**Traffic and Transport**

- 1.1 LCC in its statutory capacity as Local Highway Authority (LHA) hereby referred to as LCC LHA has reviewed the submissions supporting the DCO application against relevant national and local policies, including the NPPF, NPSNN, and the LHDG<sup>1</sup> and cannot conclude that these policy requirements have been met by the application.

- 1.2 Access to the site is proposed via an A47 link road between B4668 Leicester Road, Hinckley and the M69 J2 with the inclusion of new south facing slip roads.

M69-A47 LINK ROAD GENERAL ARRANGEMENT

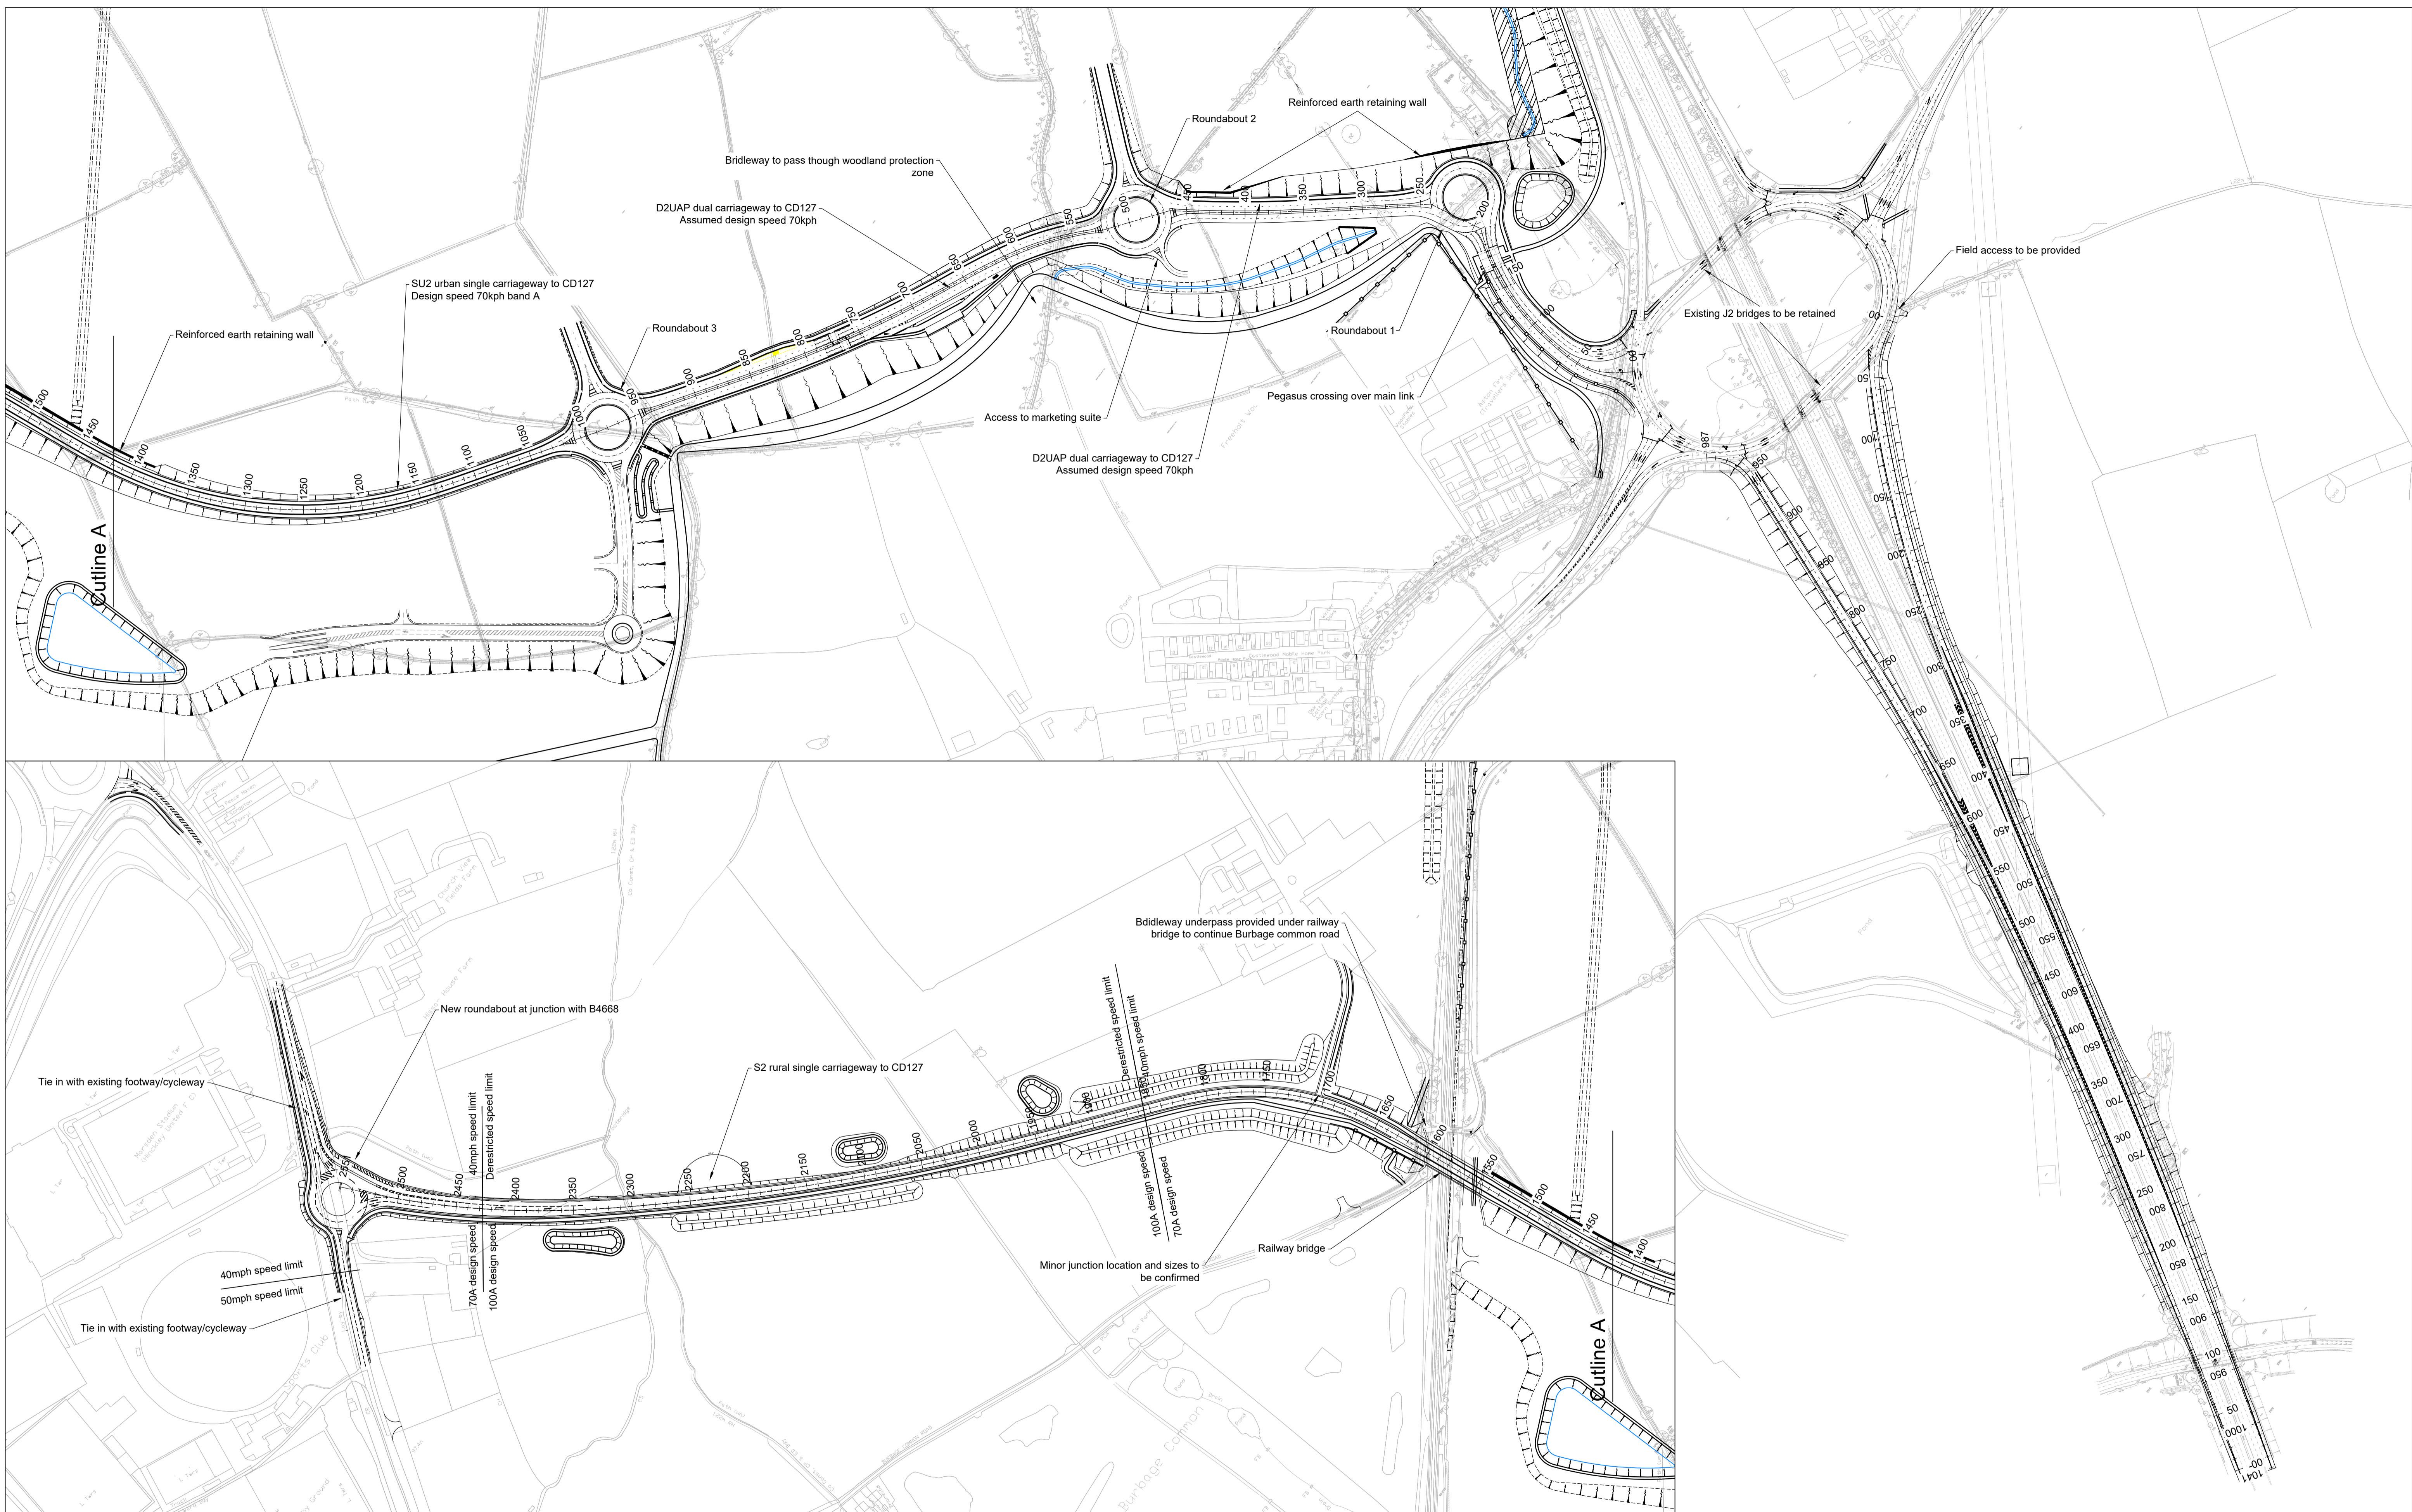
- 1.4 It is unclear if this road can be designed and delivered in accordance with the adopted design standards of LCC found within the LHDG.
- 1.5 In the absence of a Stage 1 Road Safety Audit (RSA) and Designer’s Response, LCC LHA is also unable to confirm that the proposed access will be safe and suitable.

- 1.6 LCC LHA is unable to conclude if the development access infrastructure would operate within capacity and with a reduced impact on the wider network if dualled in its entirety.

- 1.7 In addition, it would appear that no detailed junction assessments of the roundabouts along the route of the link road have been carried out.
- 1.8 There is no continuous 3m footway/cycleway along the link road.

- 1.9 No information has been provided to demonstrate that the existing structures at M69

J2 are capable of accommodating the provision of slip roads without structural integrity being compromised and no improvements for walking and cycling are included.
